**Reference:** MP 10\_0057 MOD 4/  
20 October 2011

**Council comments in relation to modification of approved building RLs and rooftops at 132-138 Killeaton Street, St Ives (MP 10\_0057 MOD 4)**

DRAWING TITLE:
BLOCK A ELEVATIONS

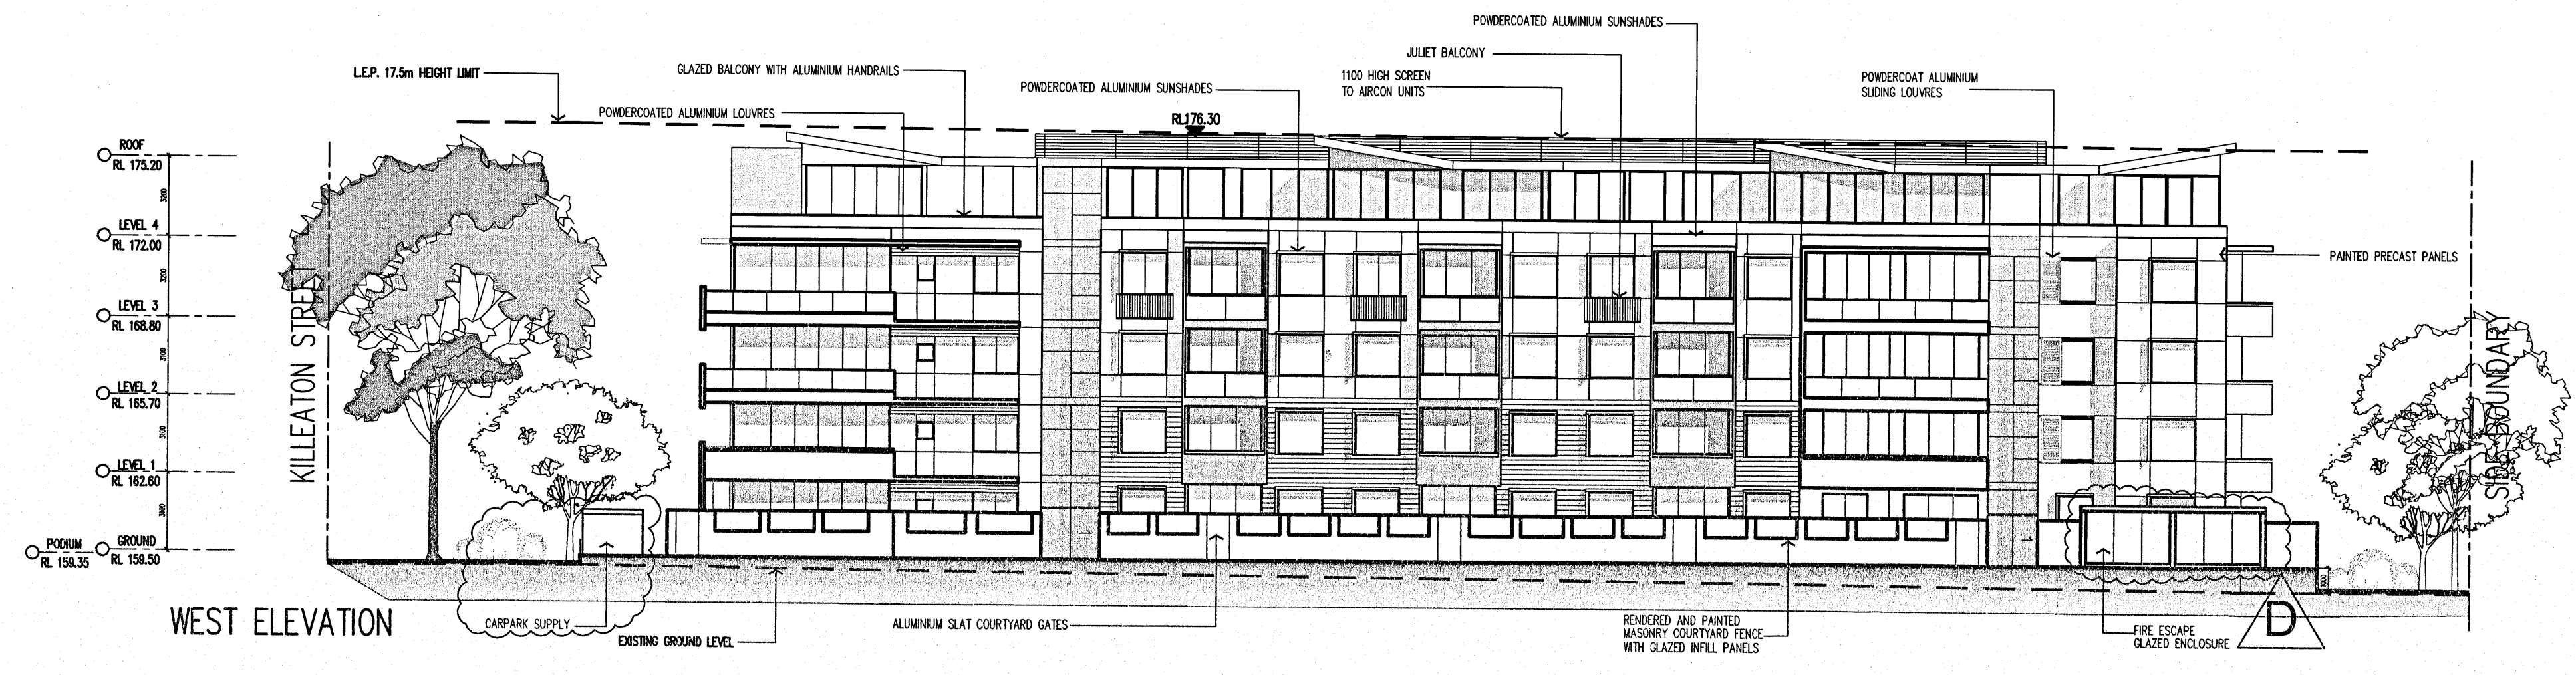
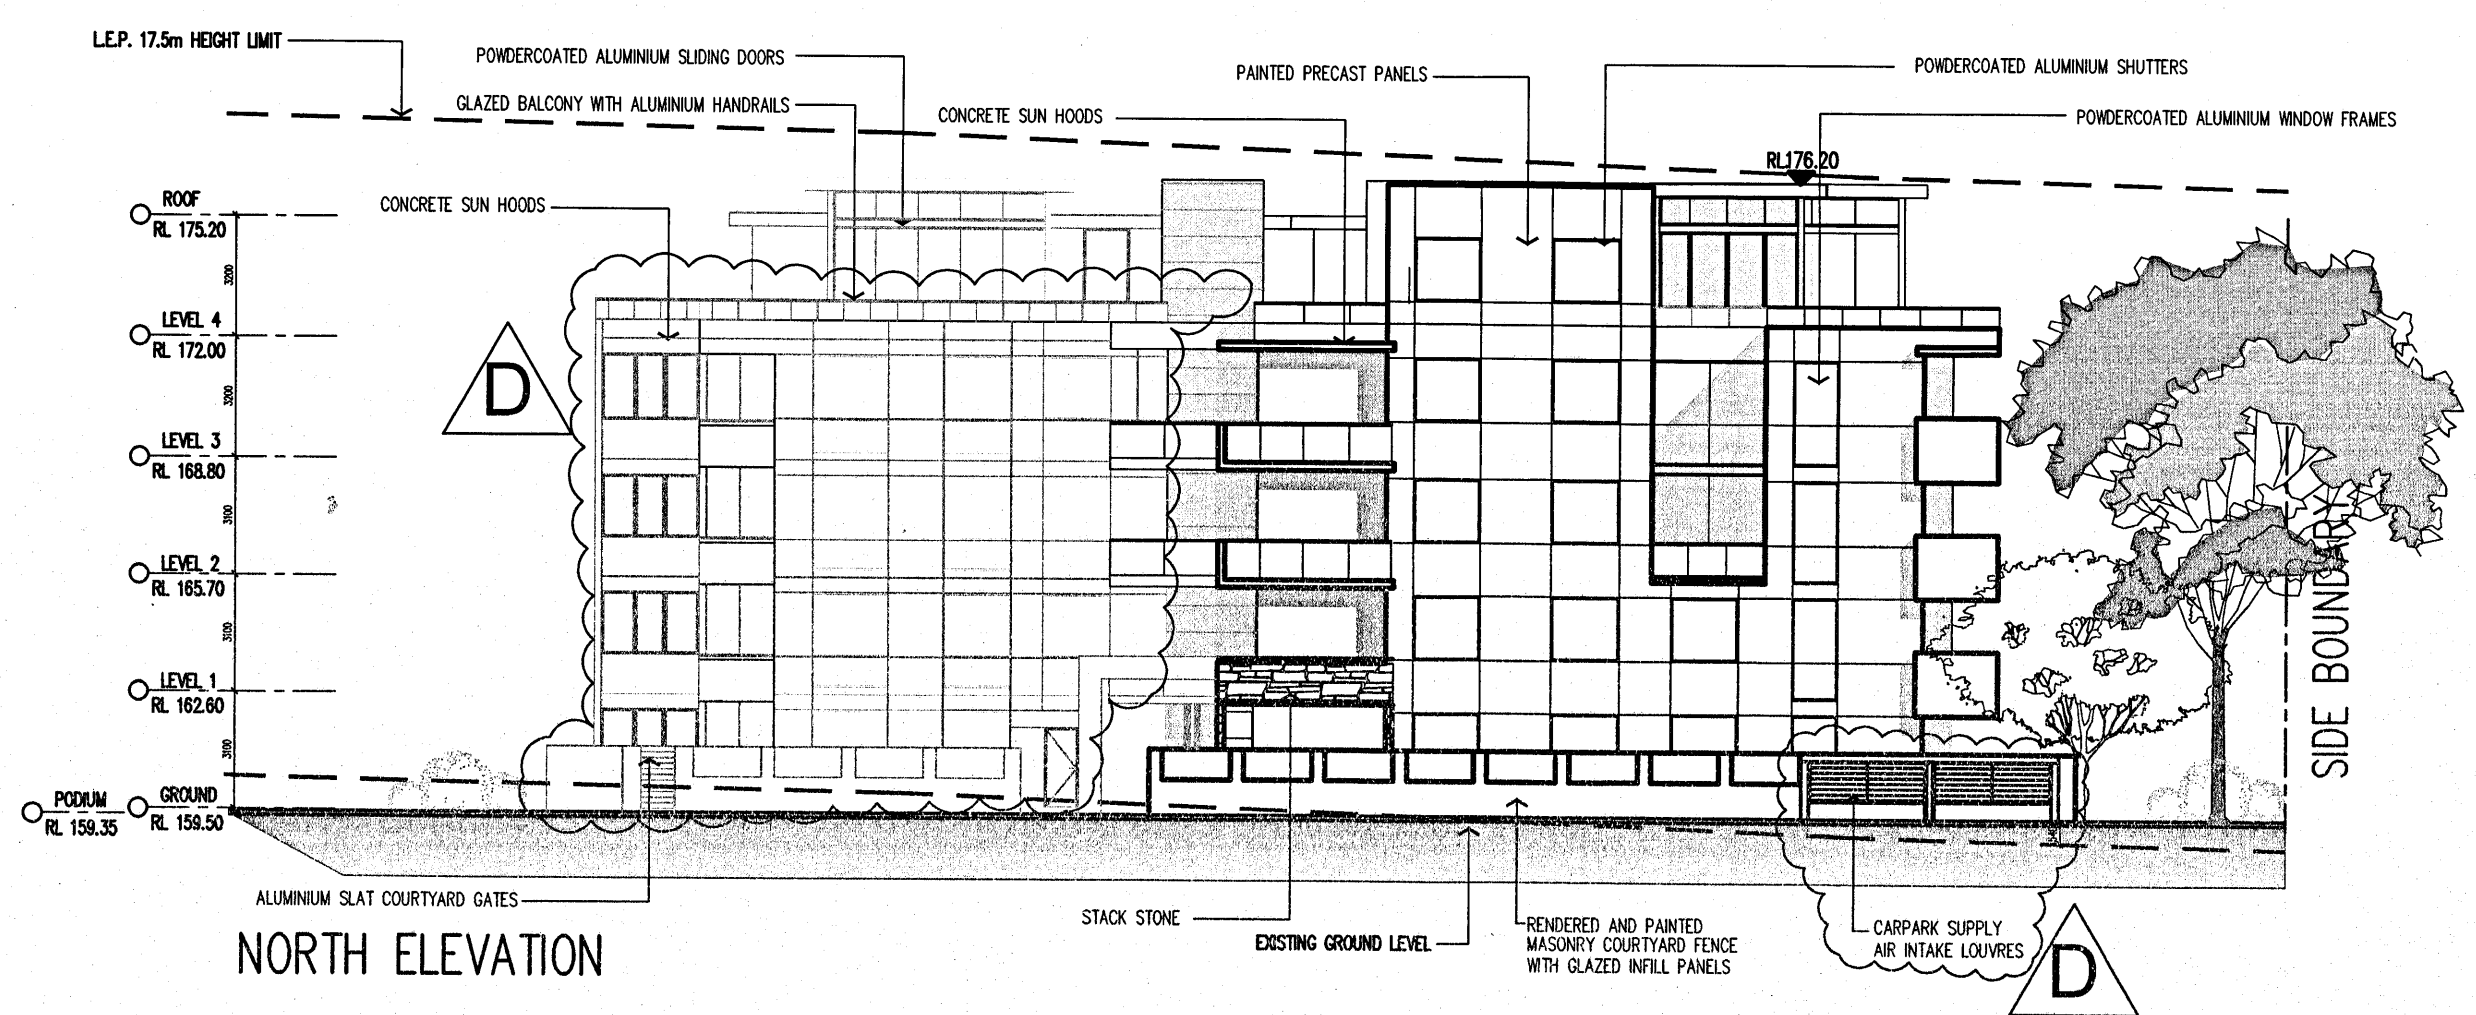
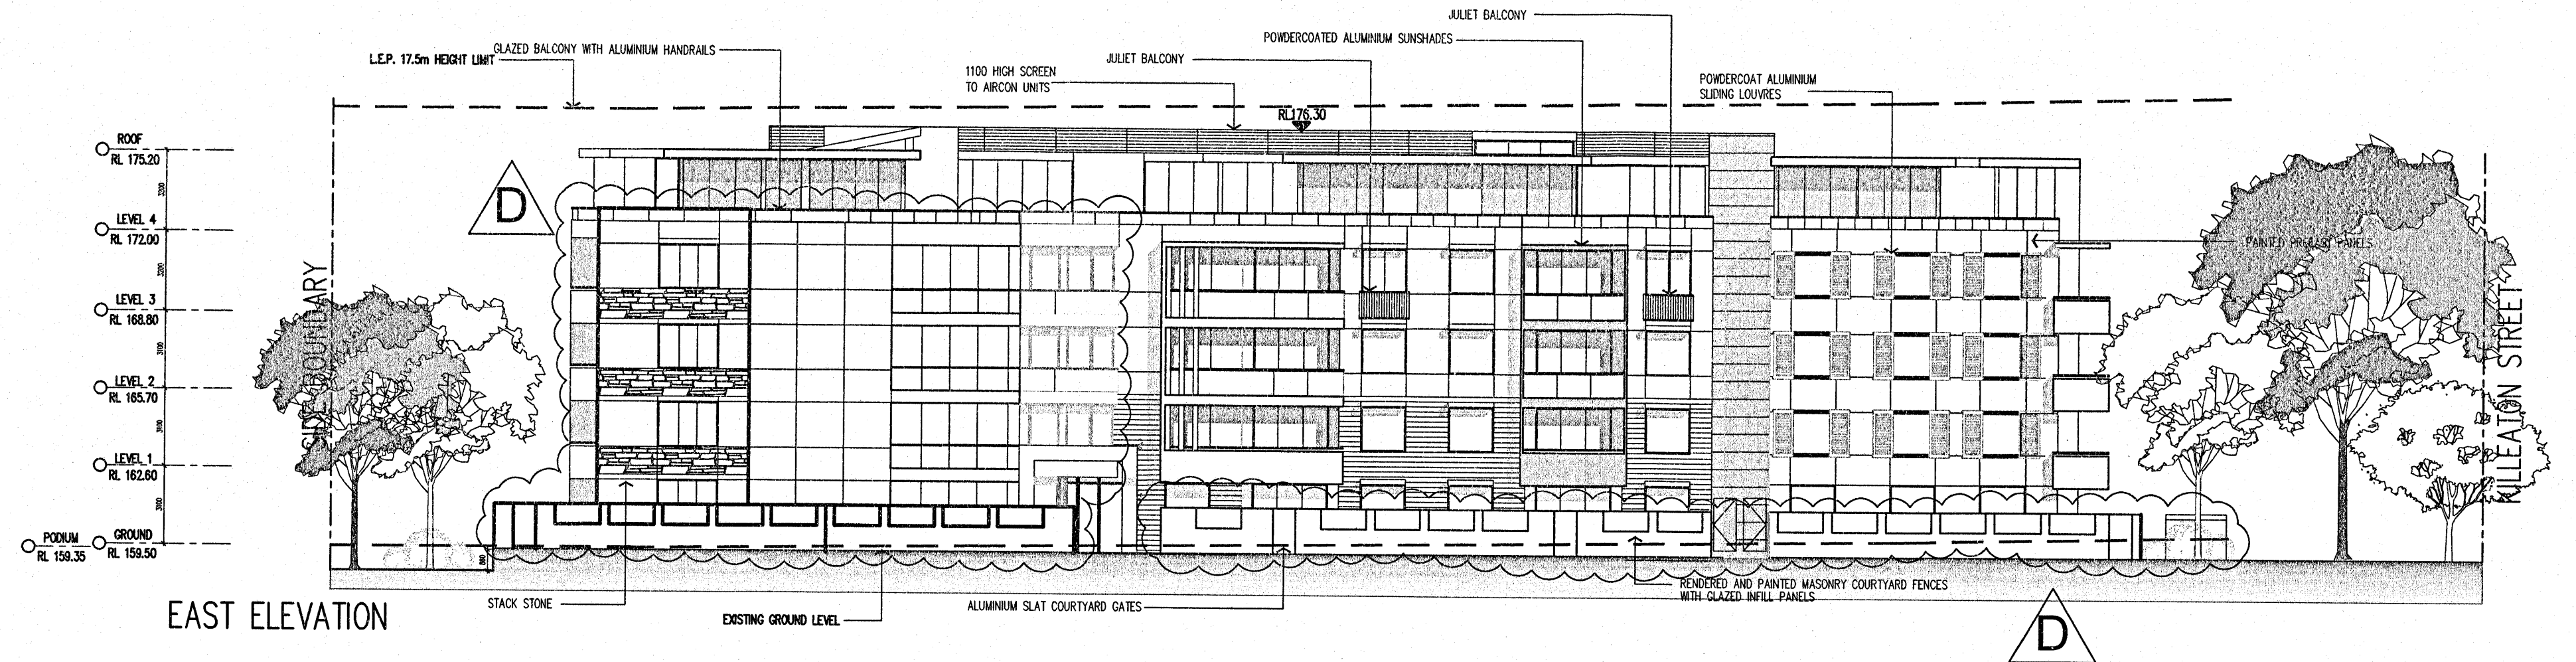
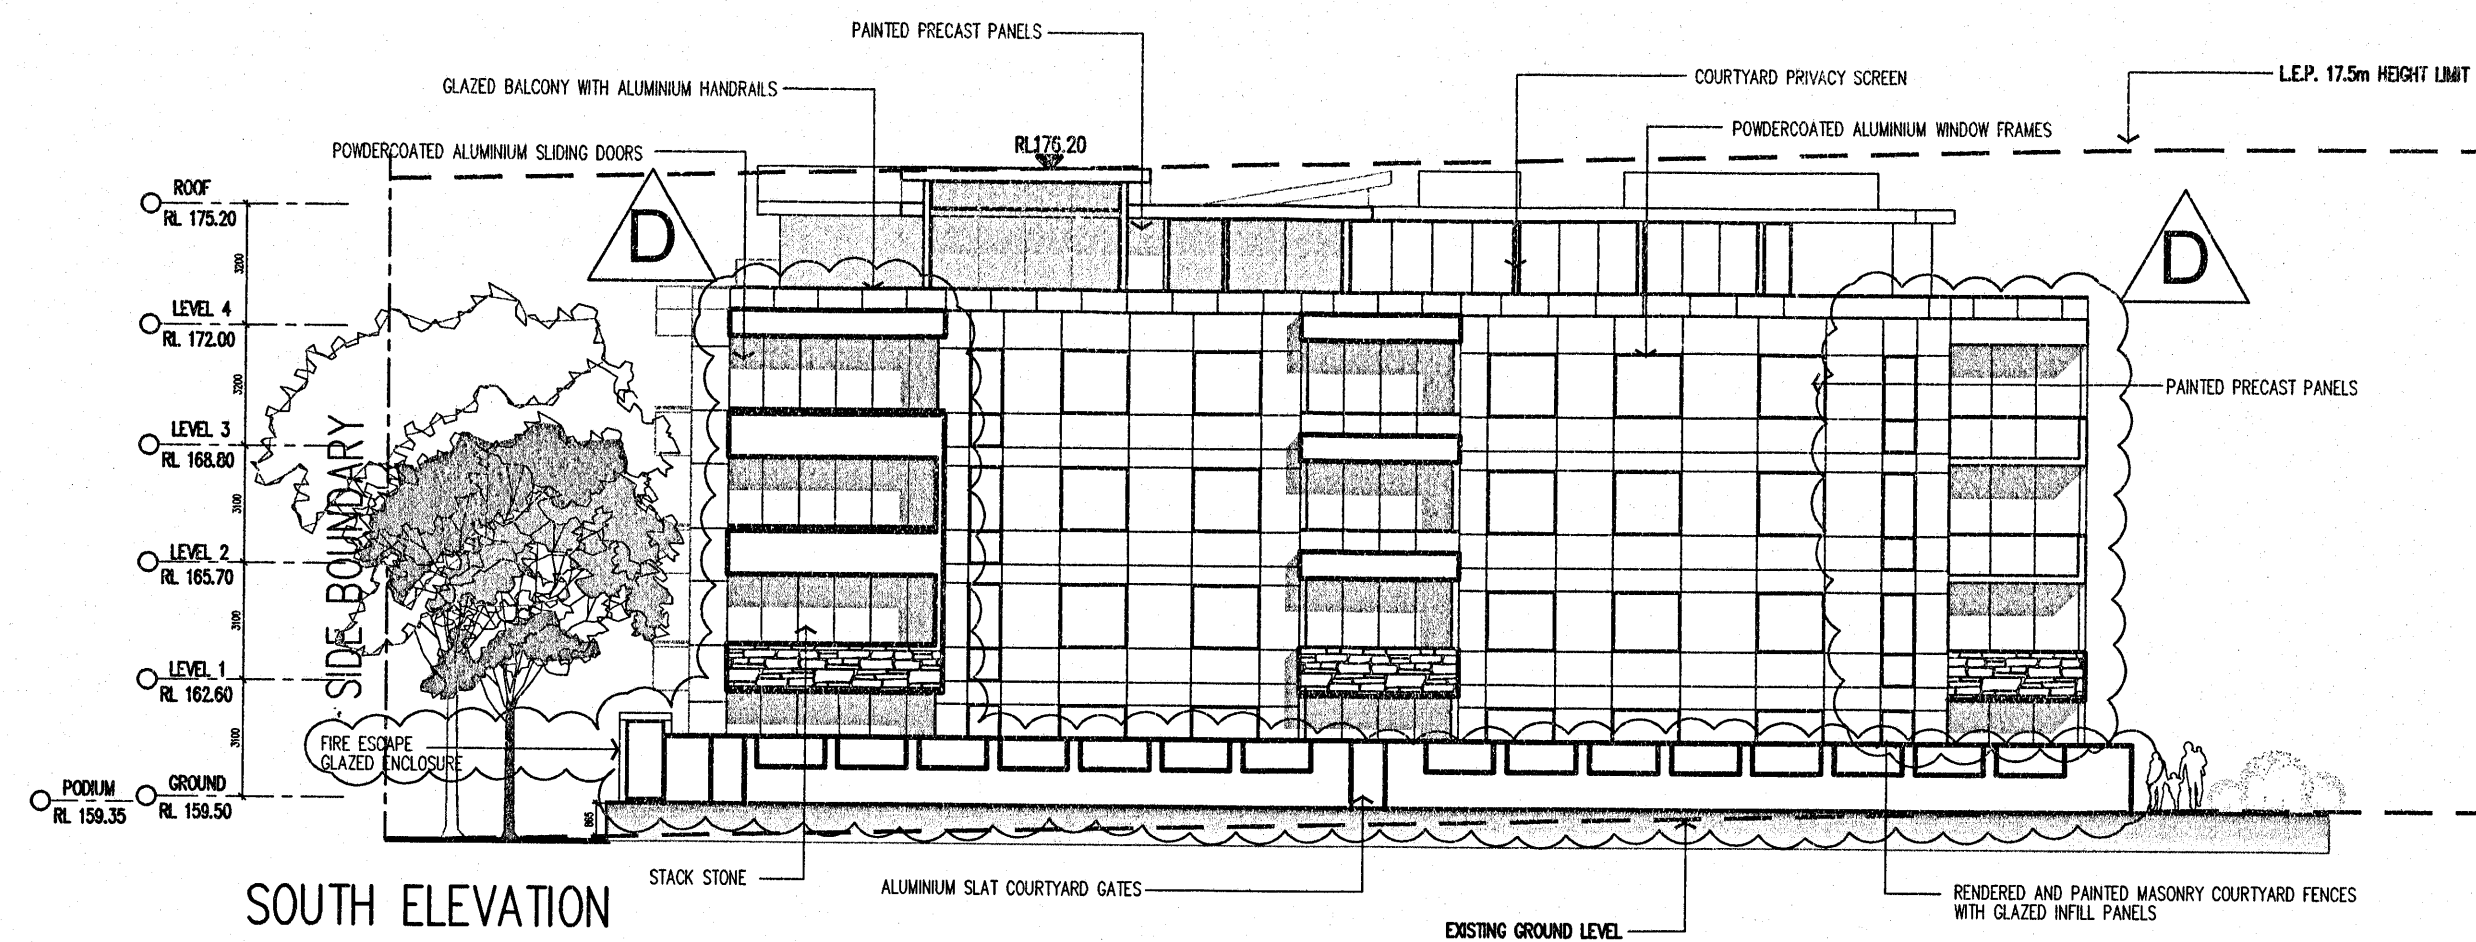
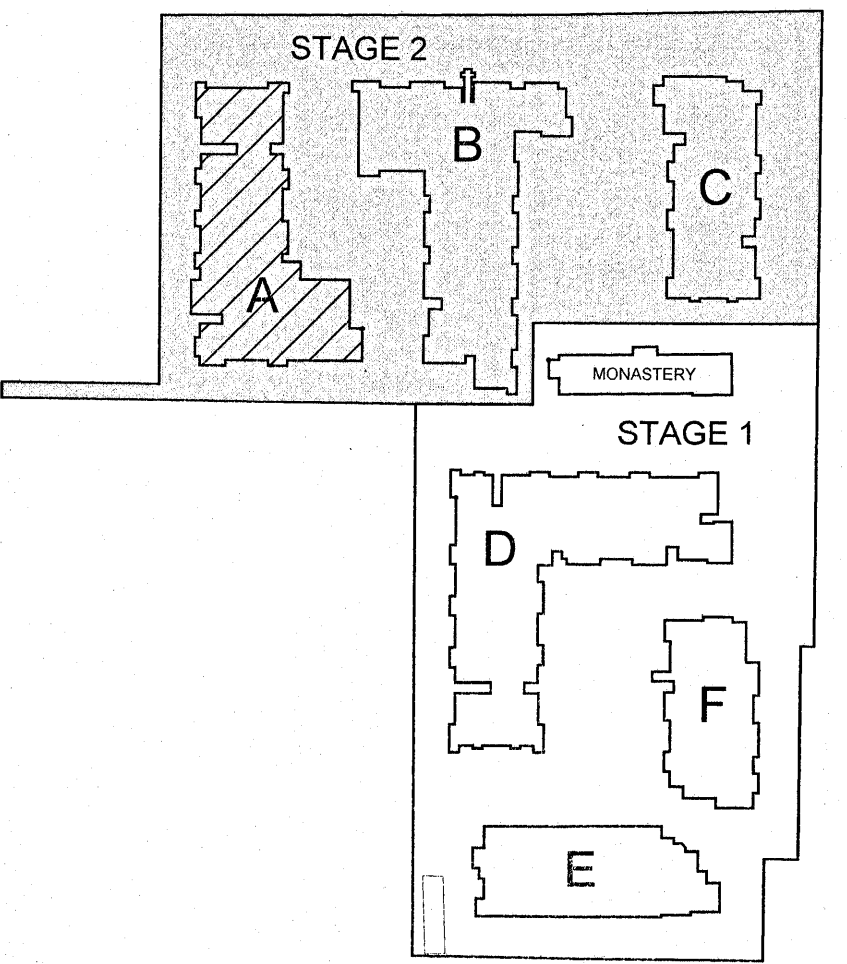
It is proposed to delete numerous raised skylights to Blocks A, B, C and D and to amend the design of those that are to be retained. The approved skylights are skillion-style and add some visual interest to the buildings. The proposed skylights have flat roofs and change the appearance of the buildings.
